**Re: 4071.10 – The Asylum – Level III Development Review Application
Response to City Staff Comments**

Below are our responses to staff comments that you provided to us on April 14 for the proposed Asylum project.

K1 SPORTS BAR CANOPY FRAMING PLAN
1/4" = 1'-0"

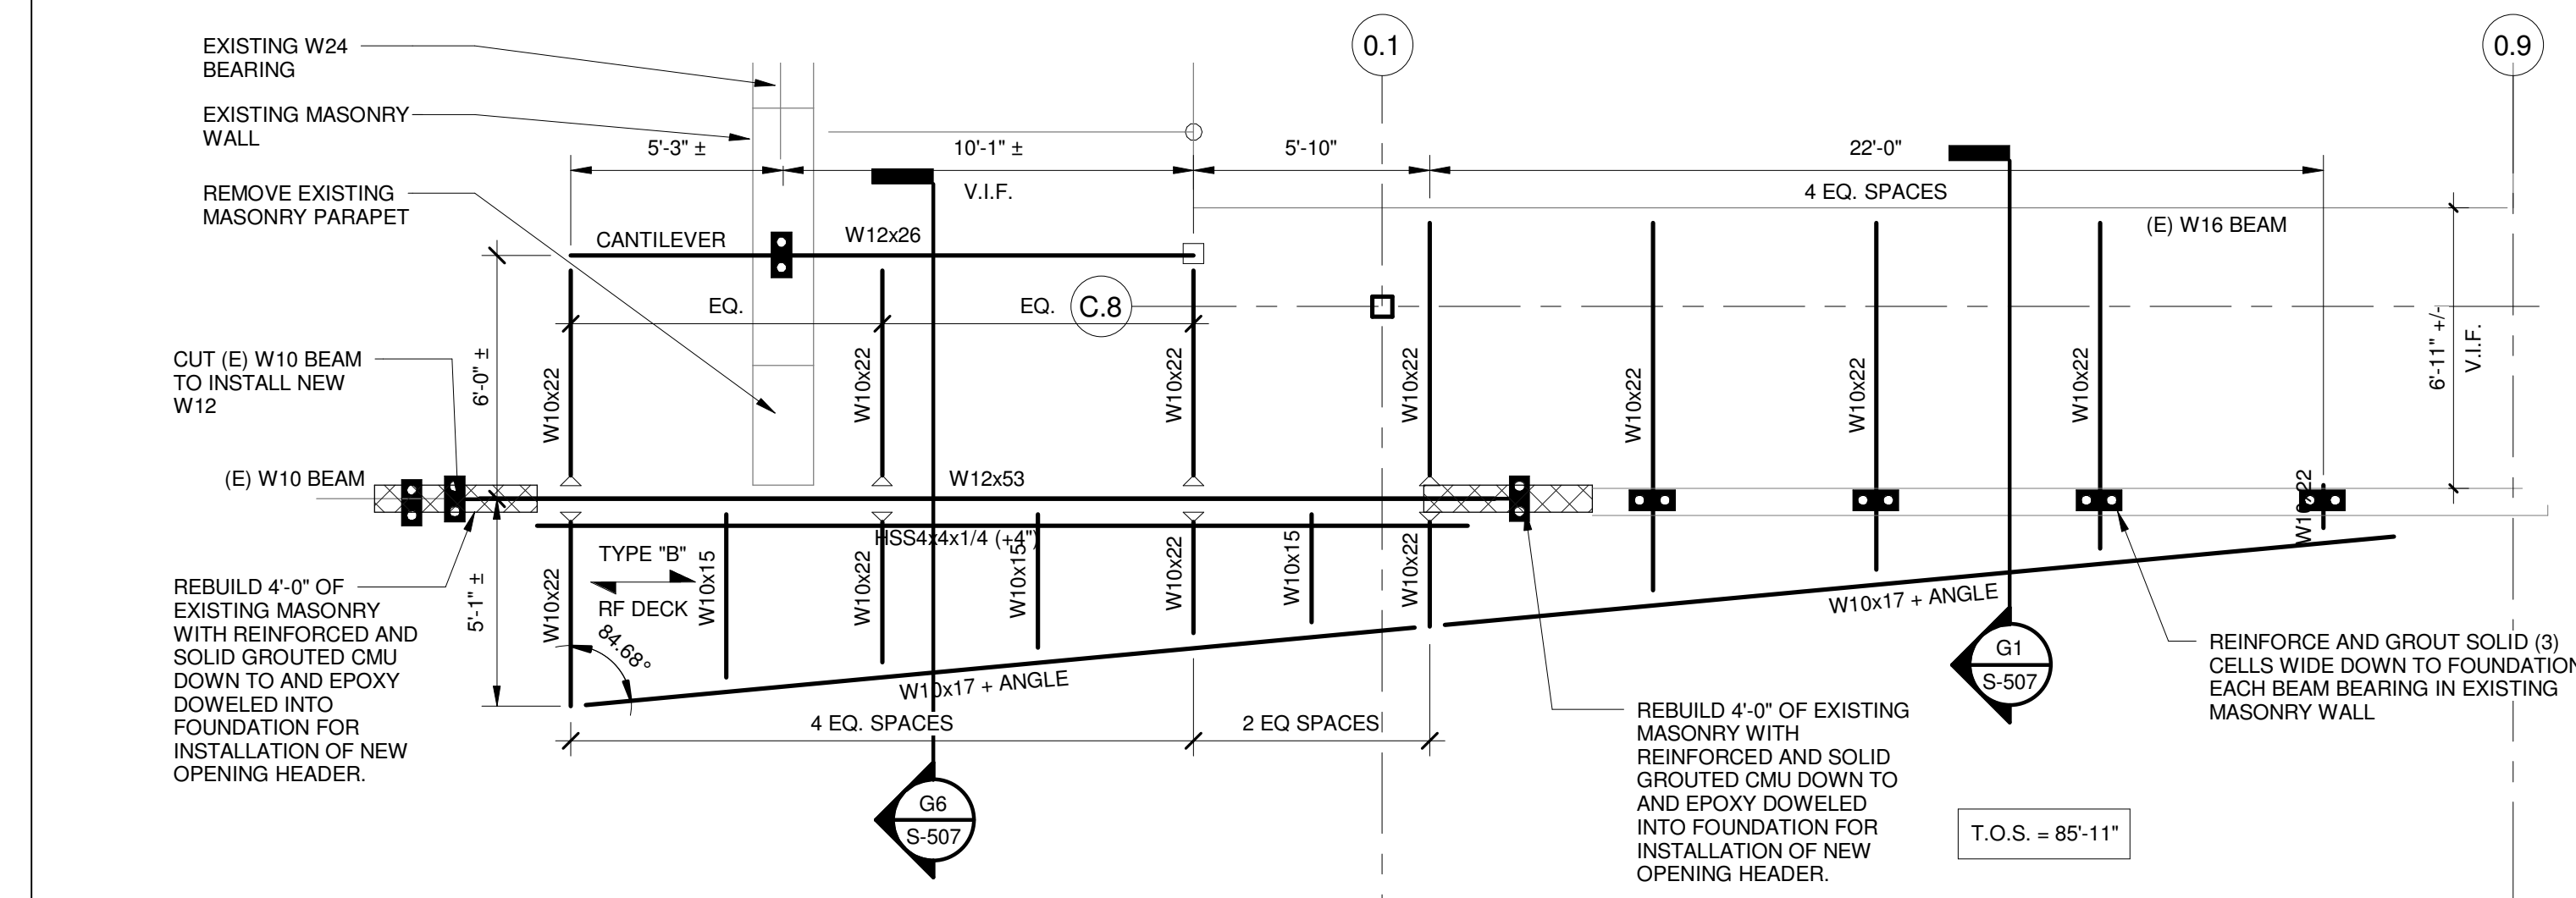
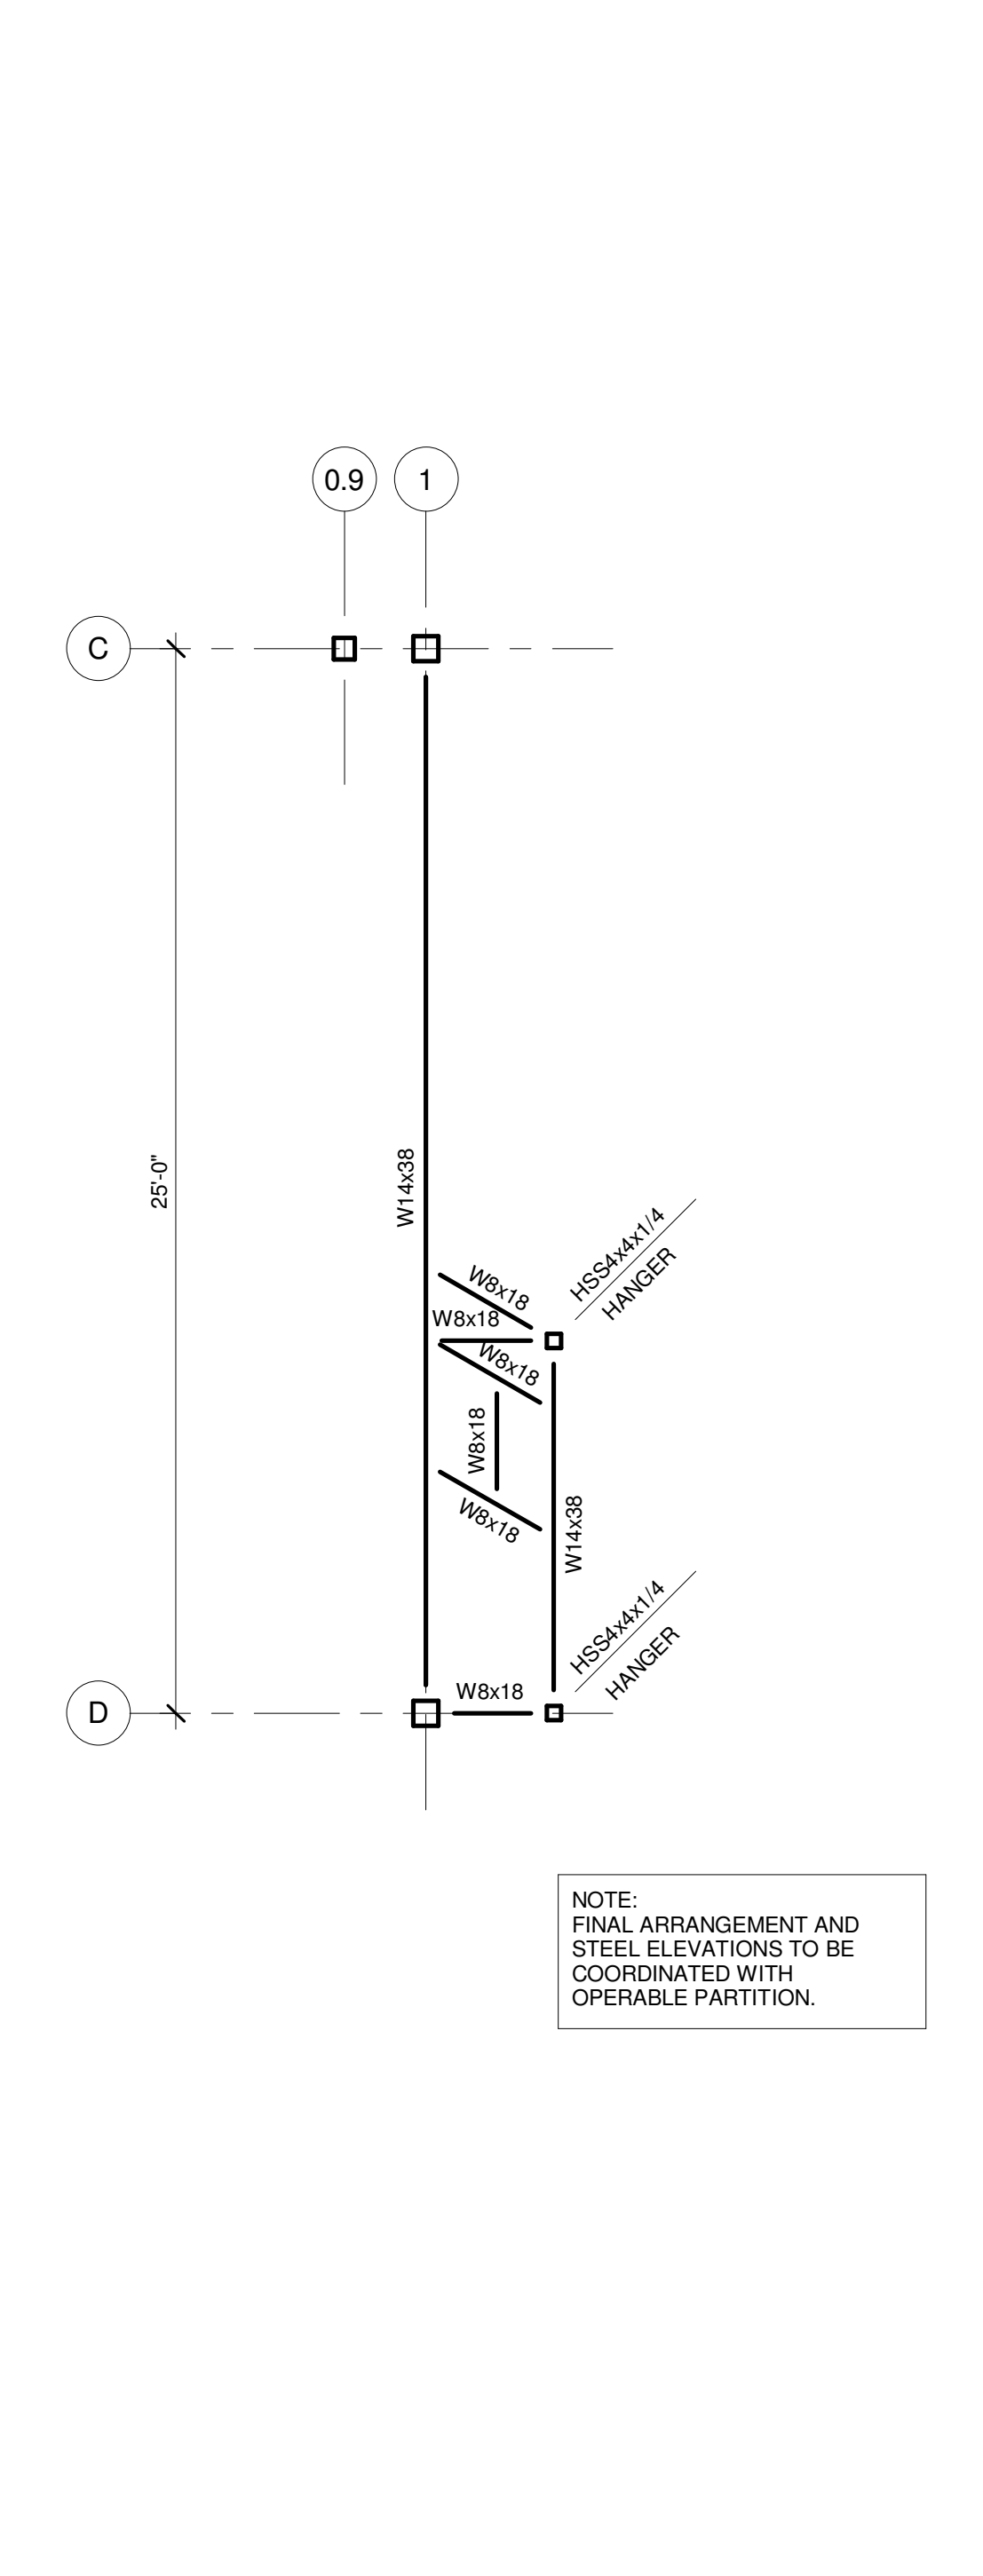
2. Provide more info on the canopies that stick out into the street r-o-w. The Center Street one is particularly large. For example, the materials, design and minimum clearance height for pedestrians **All three canopies will be design to look and act the same, but will be of varying lengths as outlined below. The canopy material will be a light grey colored metal panel on the fascia and soffit.**

Sports Bar Canopy: Canopy is designed at 8'-6" clear above the sidewalk, is 21'-9" in length and protrudes 2'-6" the Lancaster Lane side and tapers to 1'-0" at the other end.

Main Entry Canopy: Canopy is designed at 12'-0" clear above the sidewalk, is 49'-6" in length and protrudes 5'-0" at the Lancaster Lane side and tapers to 4" at the other end.
